April 2, 2019

Mountain View Electric Association, Inc. (MVEA) has these comments about the following:

Project Name: Donala Water & Sanitation Minor Site

Project Number: PPR 1912

SITE LANDSCAPE PLAN
MINOR SITE DEVELOPMENT PLAN
DONALA WATER AND SANITATION DISTRICT

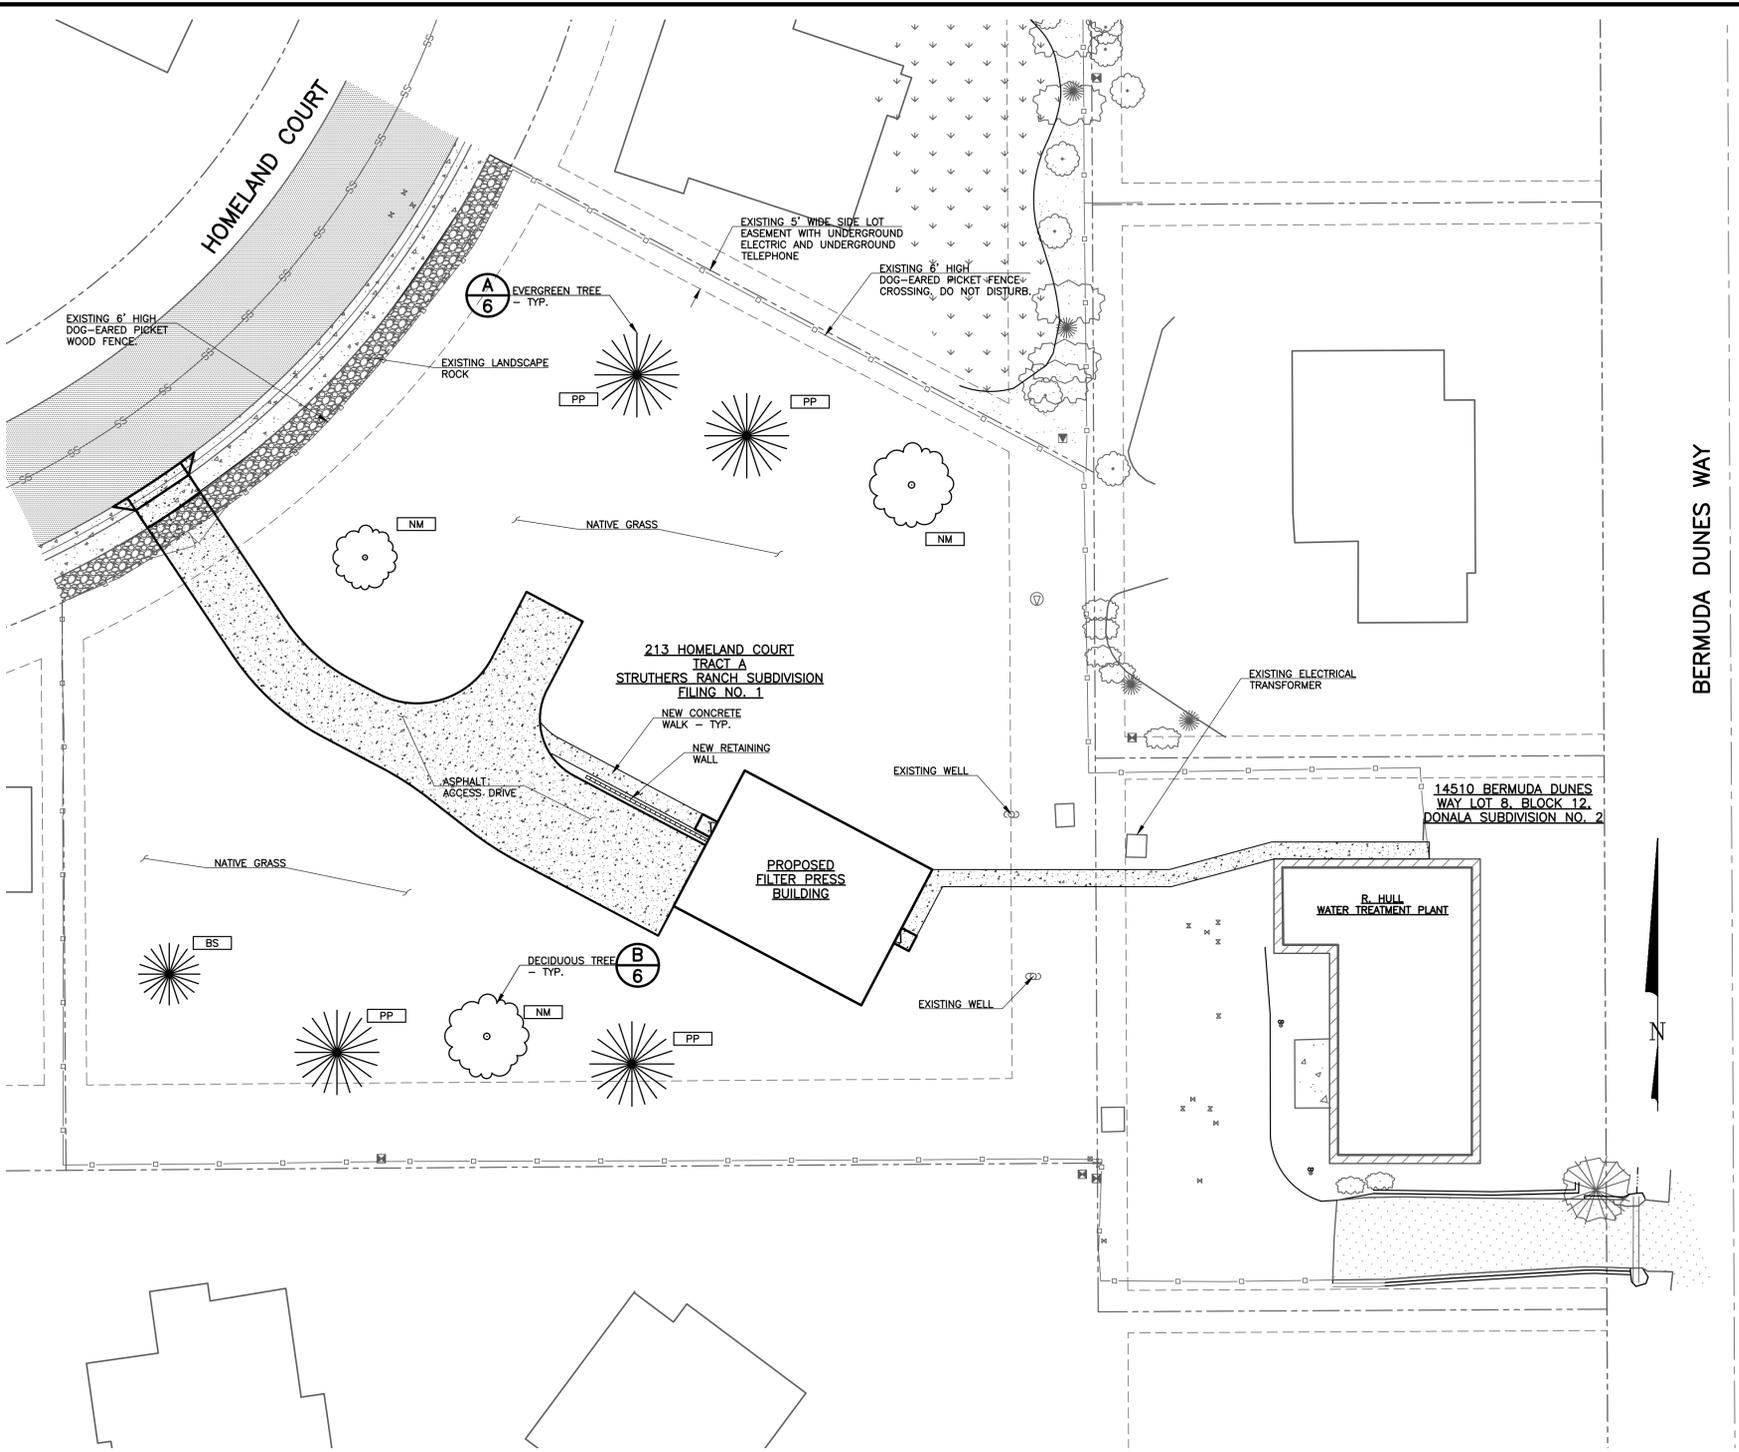
Utilities easements were granted in the recorded plat of Struthers Ranch Subdivision, Filing #1. If additional services are required MVEA will work with the owner to acquire these services with easements. MVEA requests no trees or shrubs be planted, or placing of sound barrier walls/fences within ten (10) feet of any existing or newly constructed electrical facilities.
